ANNEX 8

Technical note:

Technical impacts of the proposed Riverside Energy Park on the existing Riverside Resource Recovery Facility

Illustrative Site Layout Plan

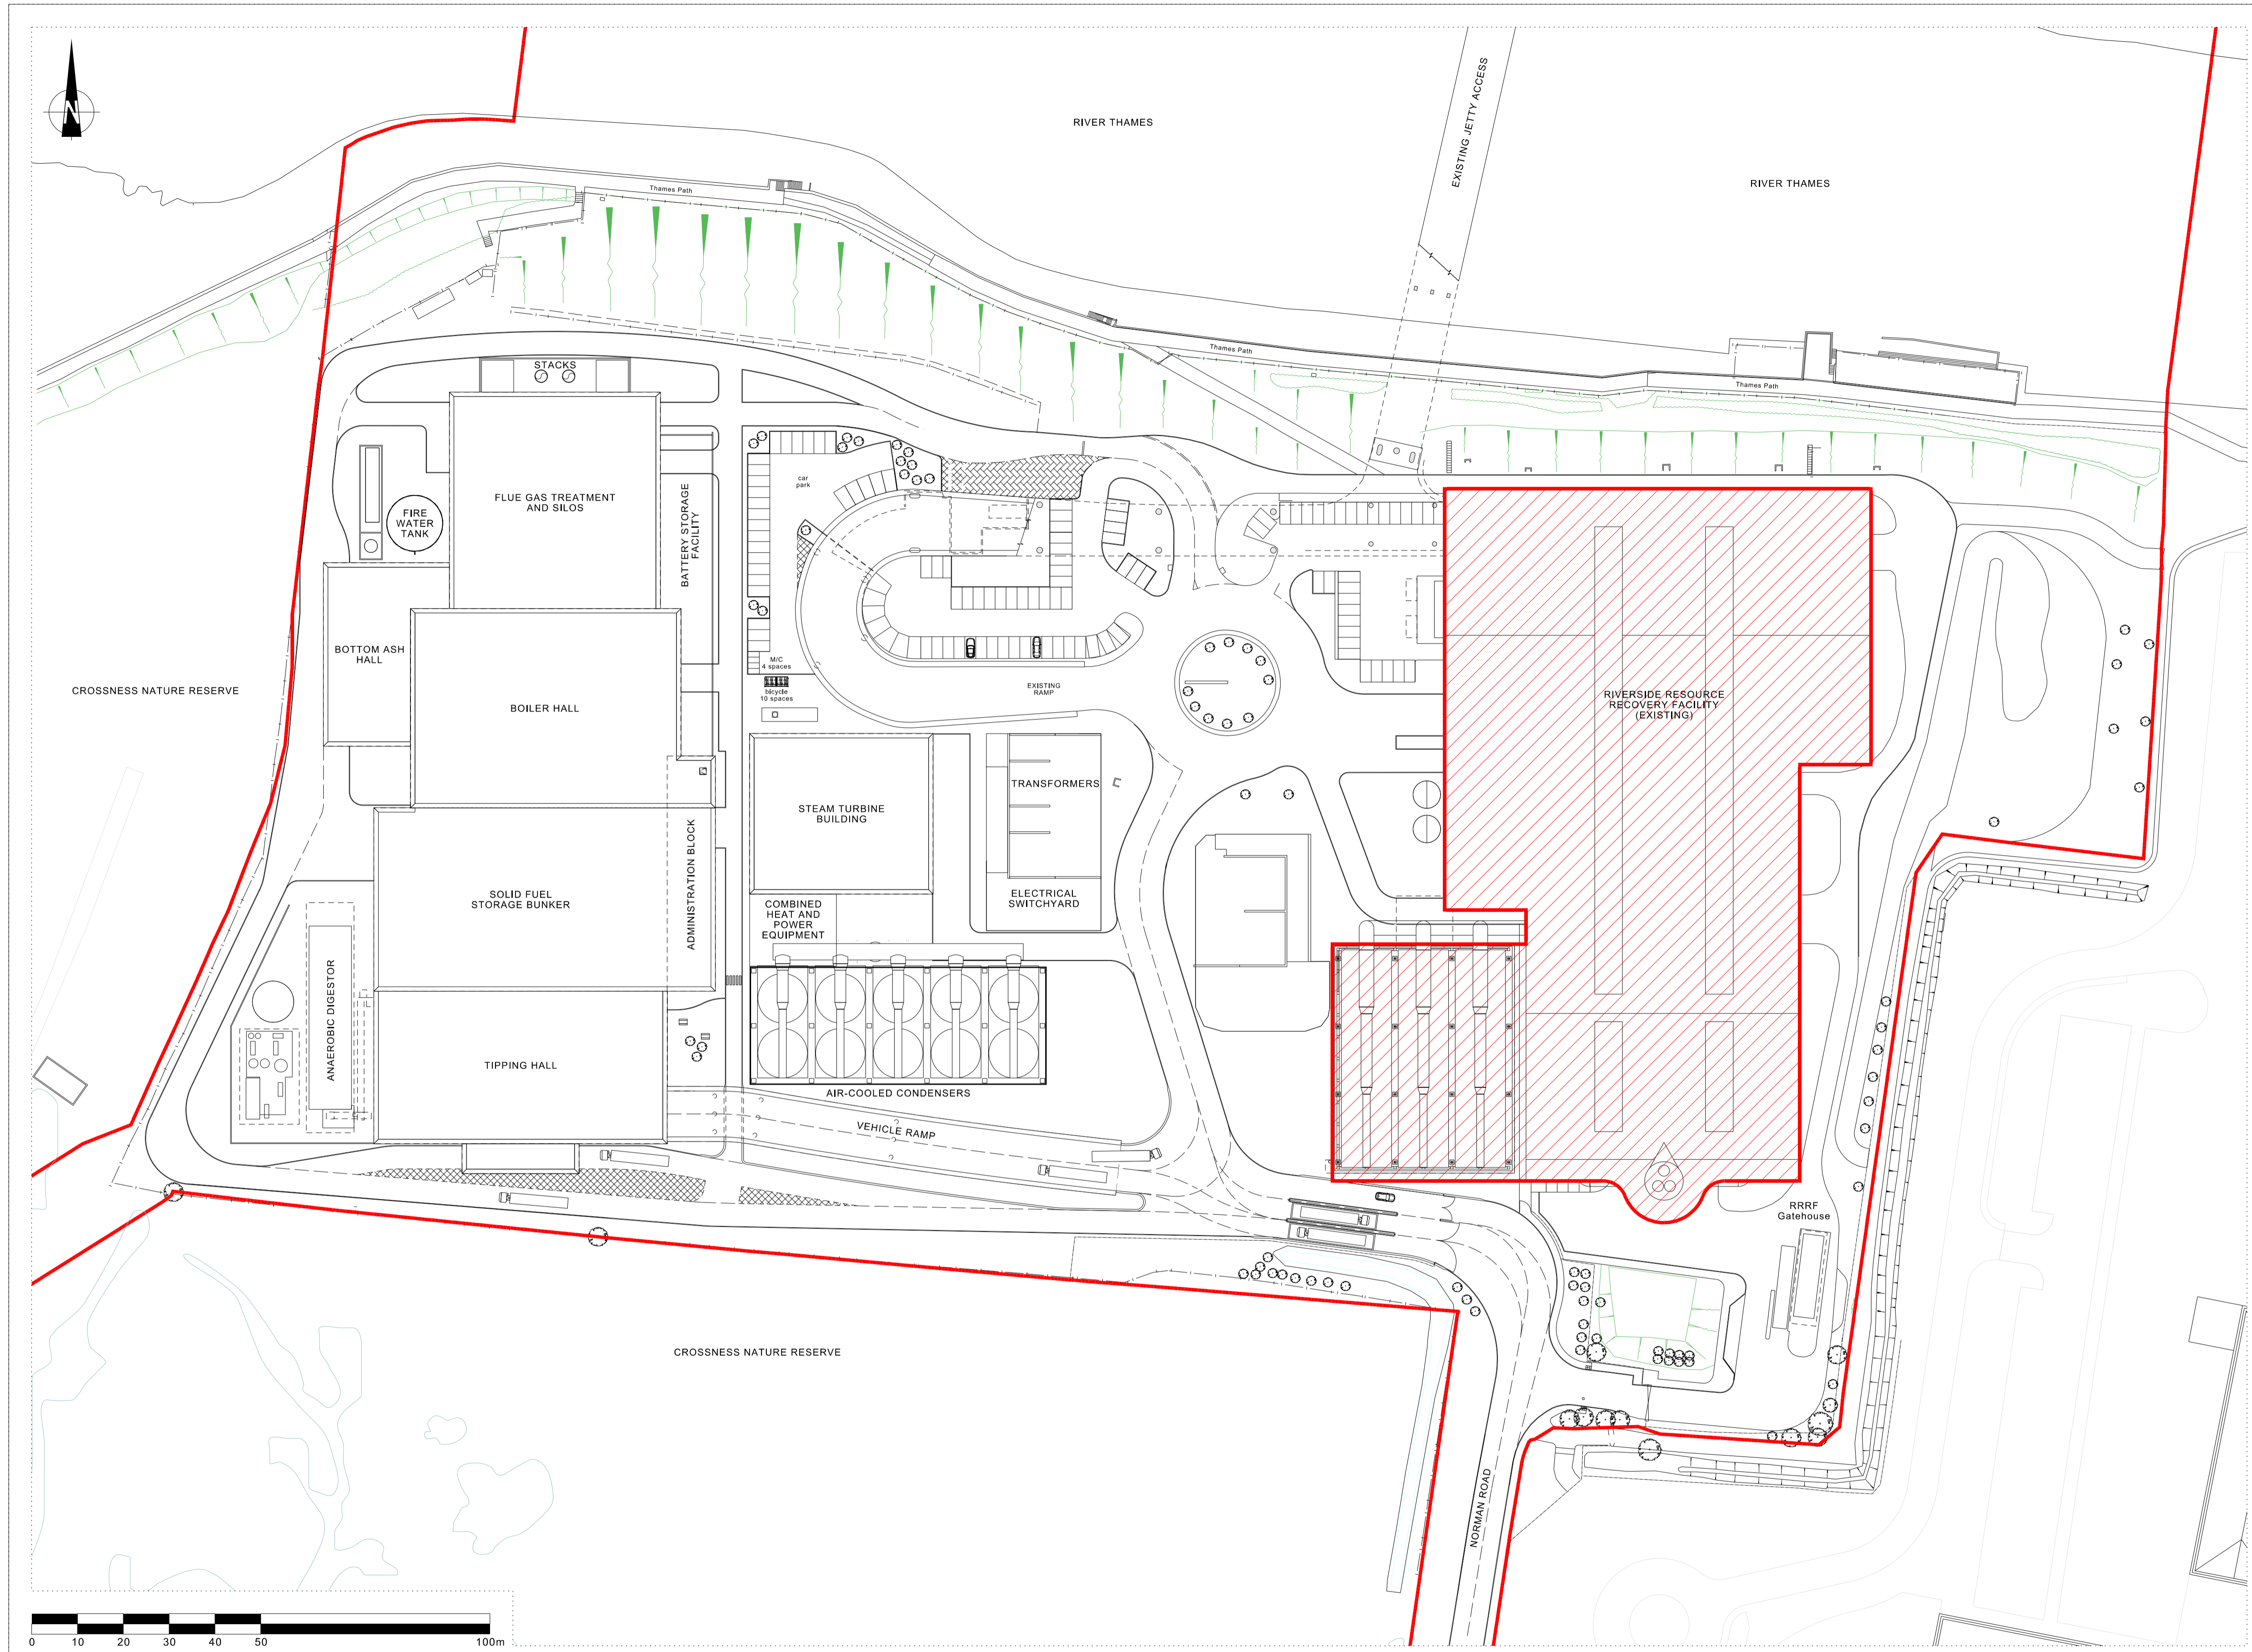
| Risk ID | Risk heading | Risk event <i>There is a risk that...</i> | Risk Effect <i>Which results in...</i> | Risk consequence <i>With a consequence that...</i> |
|---------|---------------------------|---|--|---|
| OPS-5 | Ash and container storage | <p>REP construction works impact on RRRL operations with the removal of the current ash storage and container area</p> <p><u>Supporting text</u> The site plan for the REPL Facility includes construction over an area currently being used for ash storage by RRRL prior to removal (see RRRL permission – area also evident on google earth). With this area unavailable the RRRL Facility need assurance on the plans for management of the existing container area in an alternative way.</p> <p>If there is no container area then it is unclear what happens in contingency event when IBA transport needs to switch to road. It would have to use a just-in-time transport system and always have a lorry available to pick up containers (or switch to bulkers and a shovel loader if viable, which has amenity/drainage impacts). A word search of some of the DCO docs (chapter 3, 7.4, K.4) but found no references to container handling arrangements for the REPL and RRRL Facilities.</p> <p><u>Source:</u></p> <ul style="list-style-type: none"> EN010093-000188-2.4 Illustrative Site Layout Plan Riverside Resource Recovery Facility: Consolidated Environmental Statement (section 17.3) | Reduced ash storage capacity for both facilities | The RRRL Facility will be required to find alternative local container storage options at a cost, either through construction of new storage or use of third party facilities. Alternatively, extra container movements at the Jetty will need to be considered with subsequent wear and tear increases on the equipment. |

| Risk ID | Risk heading | Risk event <i>There is a risk that...</i> | Risk Effect <i>Which results in...</i> | Risk consequence <i>With a consequence that...</i> |
|---------|-----------------------------------|---|---|---|
| OPS-7 | Fire hazard | <p>The AD facility will have flammable biogas, and other hazardous chemicals stored onsite</p> <p><u>Supporting text</u> The location of the AD facility is shown in the Site Layout Plan, and what appear to be a circular bio-gas store.</p> <p>There is a general reference to fire/explosion risk in Appendices K.6 Risk of Major Accidents and Disasters (page 4). This refers to shut-down protocols, but not to the presence of stored bio-gas from the AD facility. It is also noted that the battery storage facility could present a fire risk.</p> <p><u>Sources</u></p> <ul style="list-style-type: none"> EN010093-000188-2.4 Illustrative Site Layout Plan EN010093-000277-6.3 ES Technical Appendices K.6 Risk of Major Accidents and Disasters | <p>The presence of the management and storage of biogas and other dangerous substances bring an increased risk of fire and / or explosion</p> | <p>Increased severity of accident hazard in an emergency event. Potential increased insurance costs</p> |

Typical Section
Existing Wall Type 1 - Tied Sheet Pile Wall
1:50

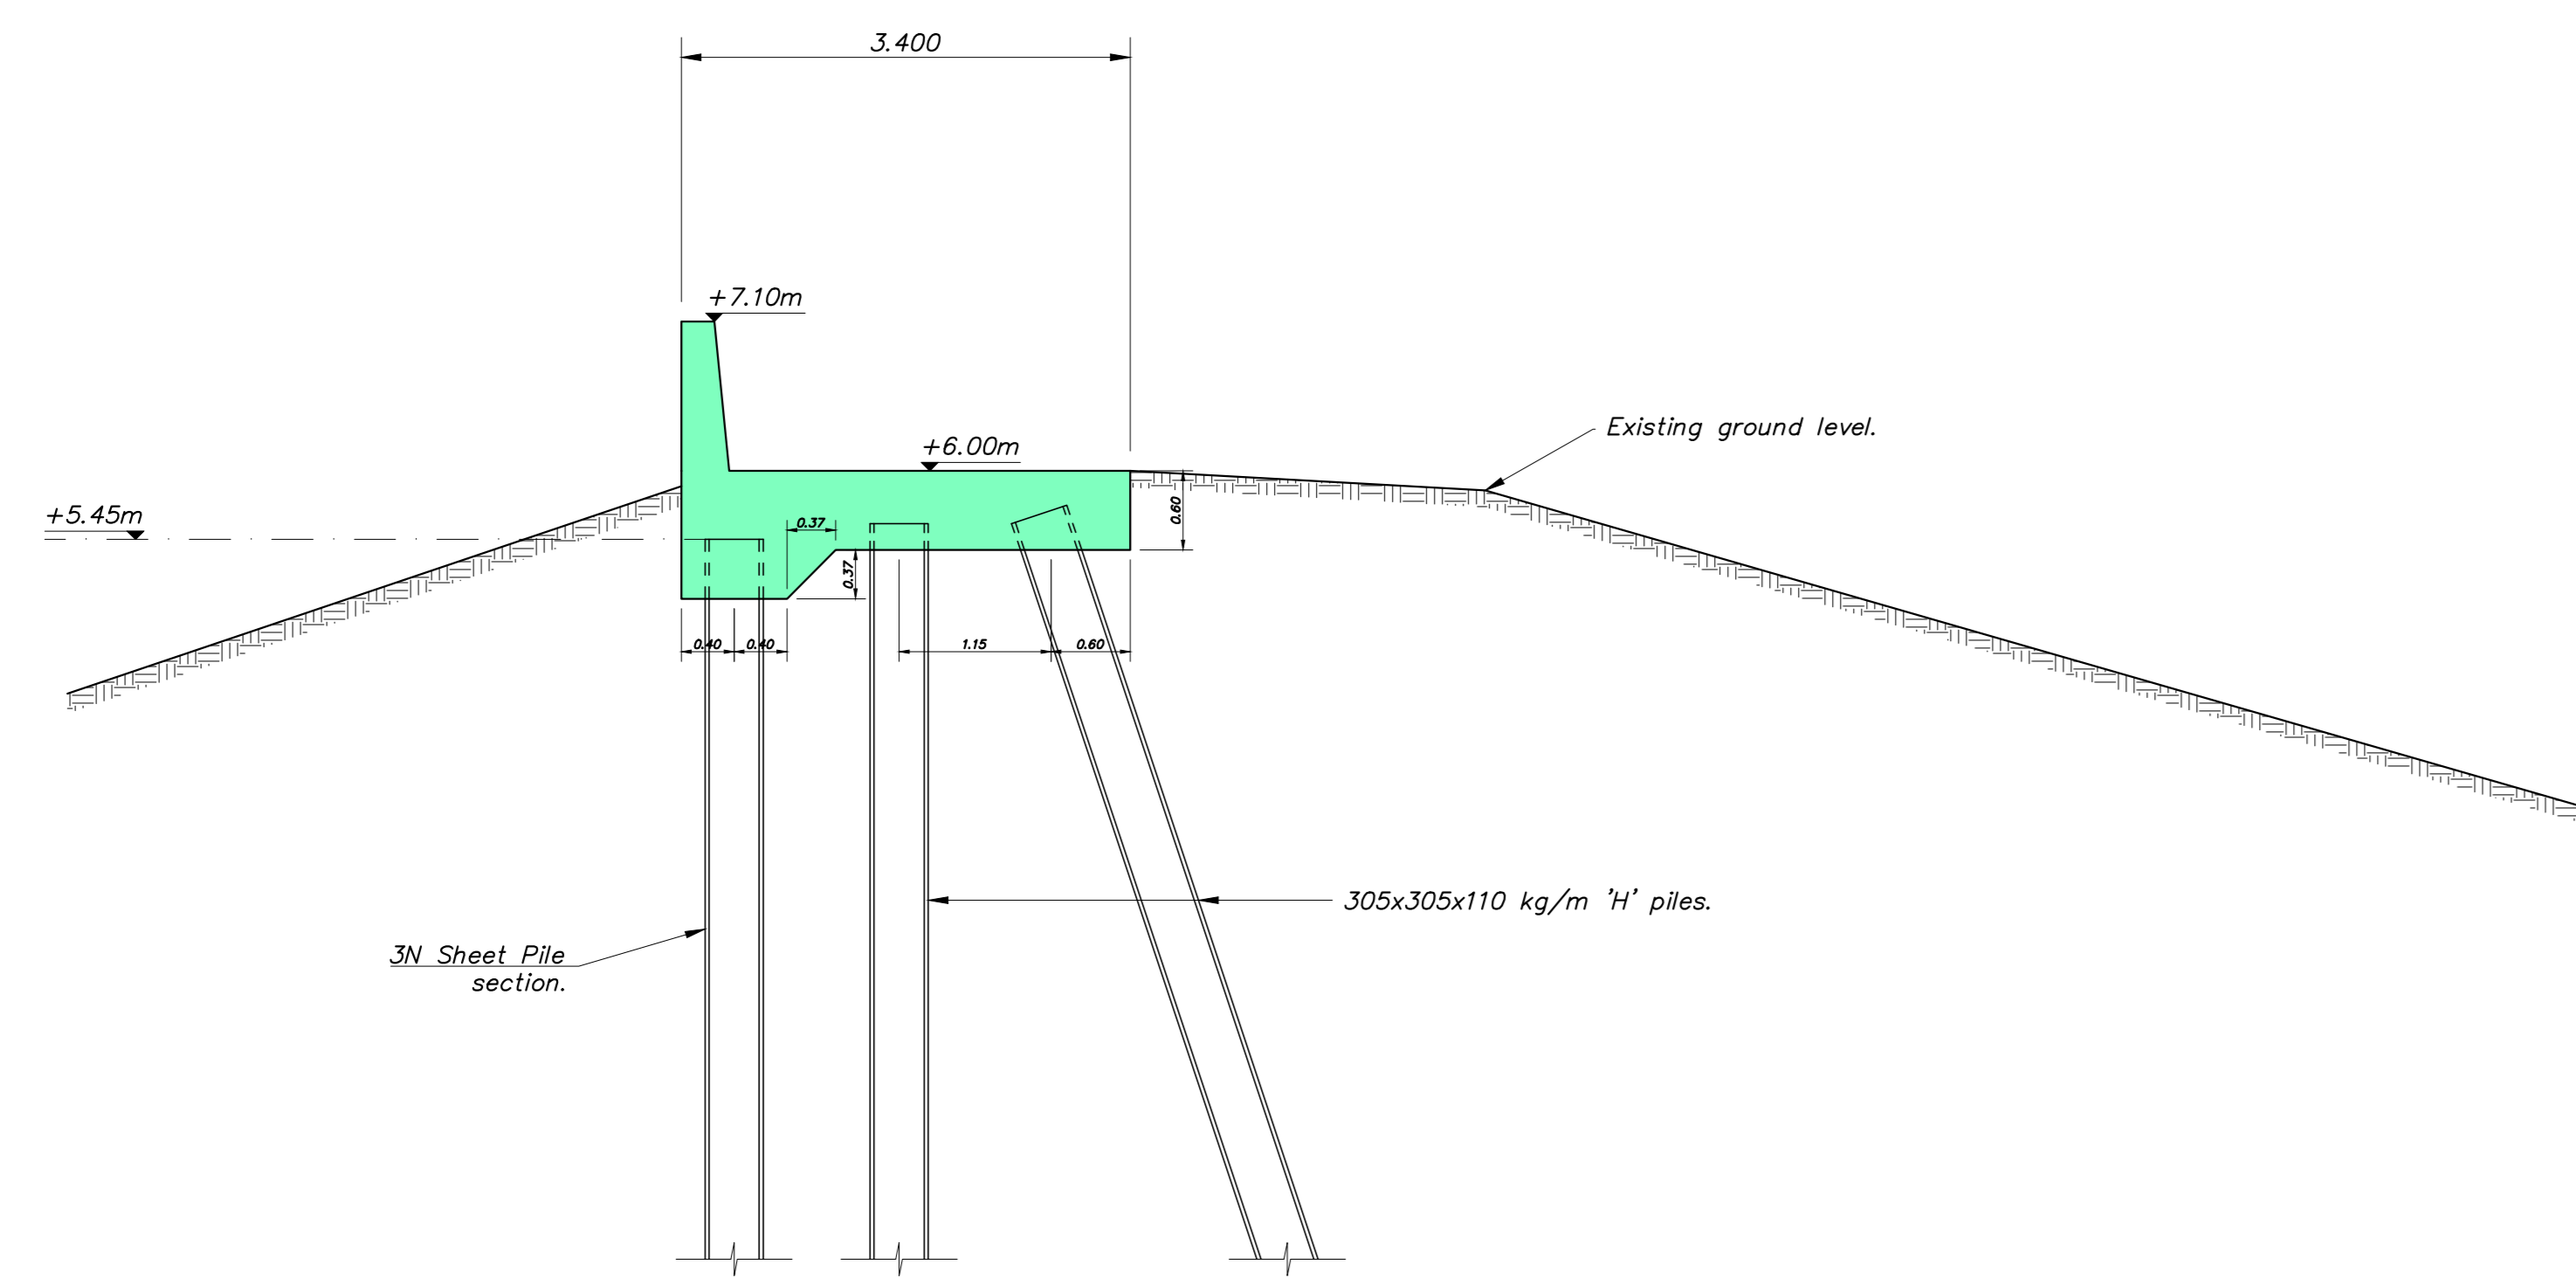
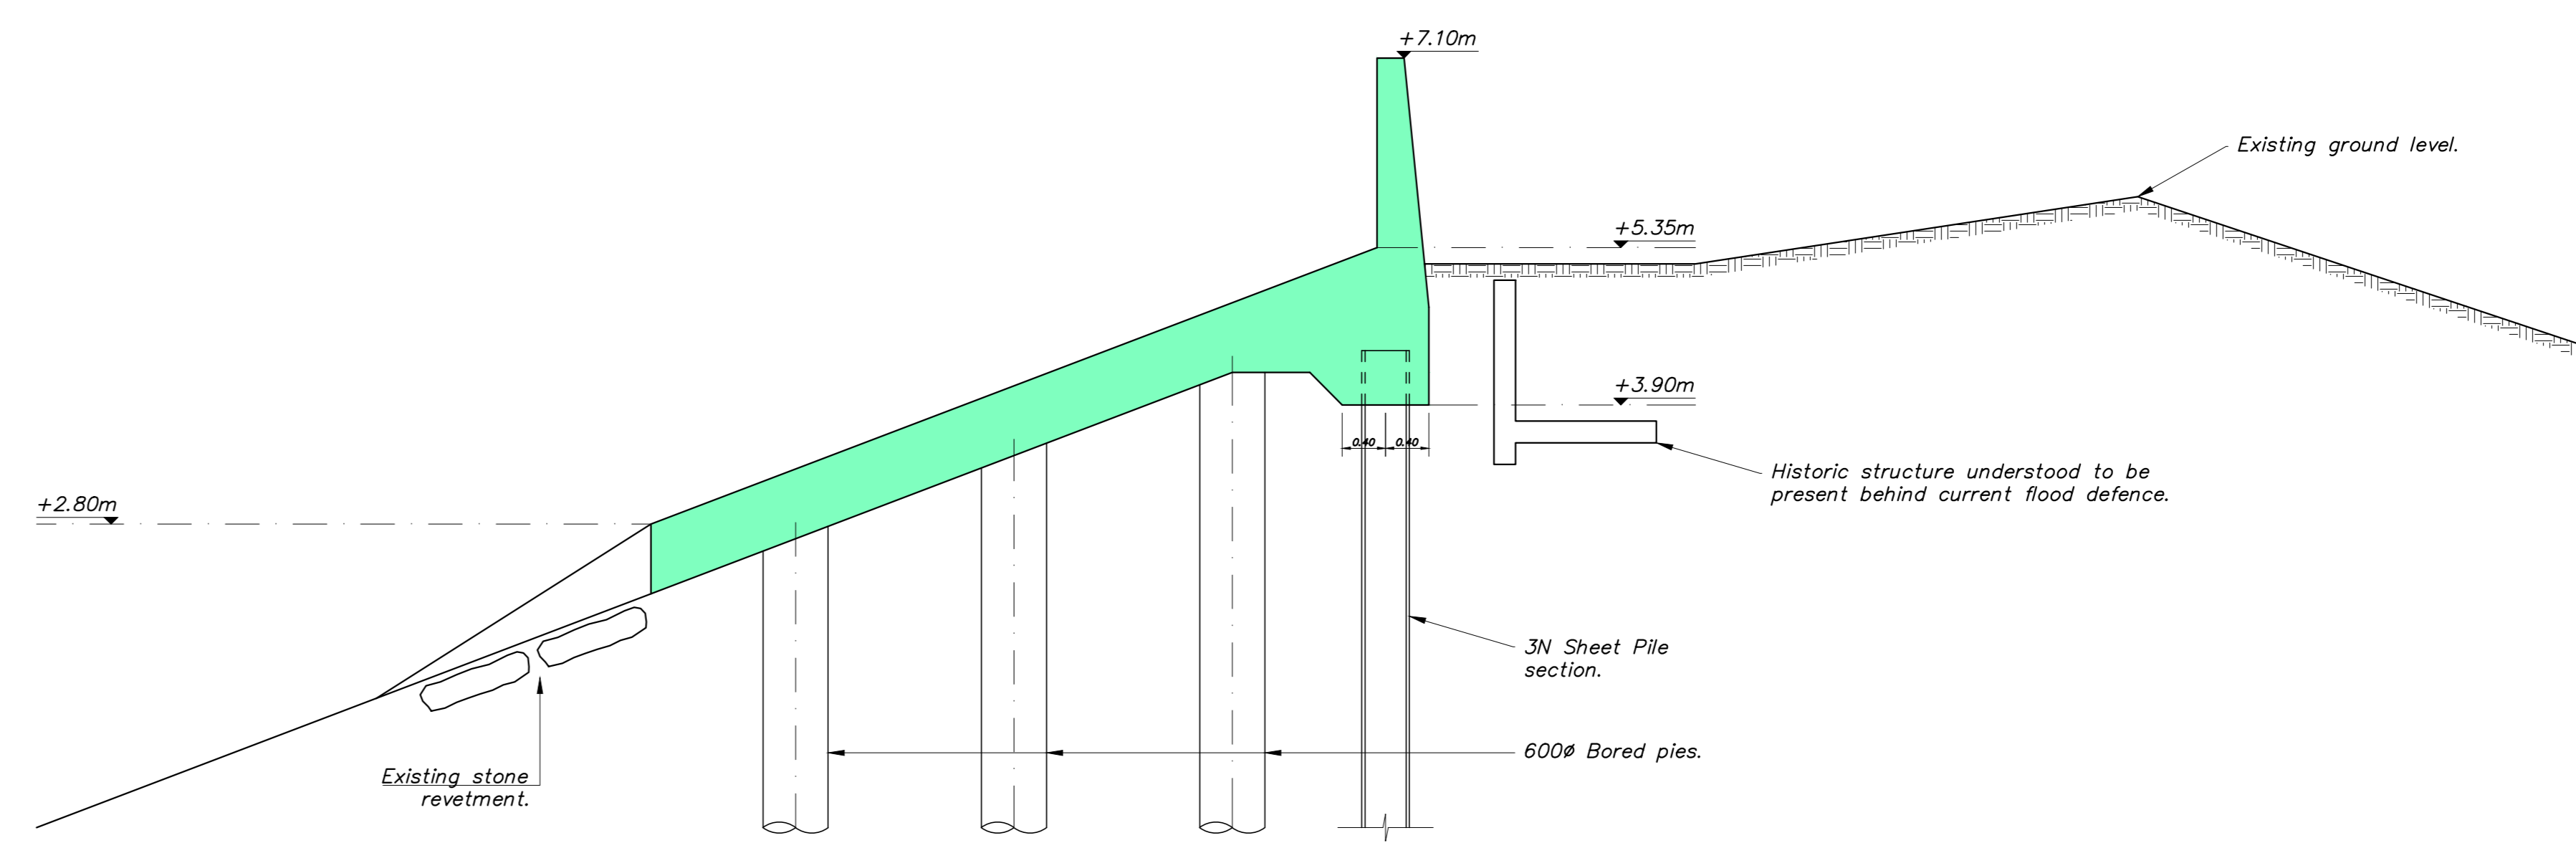
| Risk ID | Risk heading | Risk event <i>There is a risk that...</i> | Risk Effect <i>Which results in...</i> | Risk consequence <i>With a consequence that...</i> |
|-----------------|---|--|--|---|
| | | <p>Sections of the flood wall are tied back into an anchor sheet piled structure set 13m back from the front face. If any excavations are to take place in vicinity of the anchor pile, it is important to ensure that the rotational stability (and passive resistance) available to these piles is not compromised.</p> <p>The condition of the foreshore embankment needs to be maintained to ensure general stability of the wall and to prevent corrosion of sheet piling.</p> <p>The risk of vibration (through piling works) impacting upon the structural integrity of the flood wall needs to be assessed.</p> <p>Dewatering works may also impact on the stability of the surrounding area.</p> <p><u>Source:</u></p> <ul style="list-style-type: none"> EN010093-000211-5.2 Flood Risk Assessment, Appendix E Flood Defence Condition Survey | | |
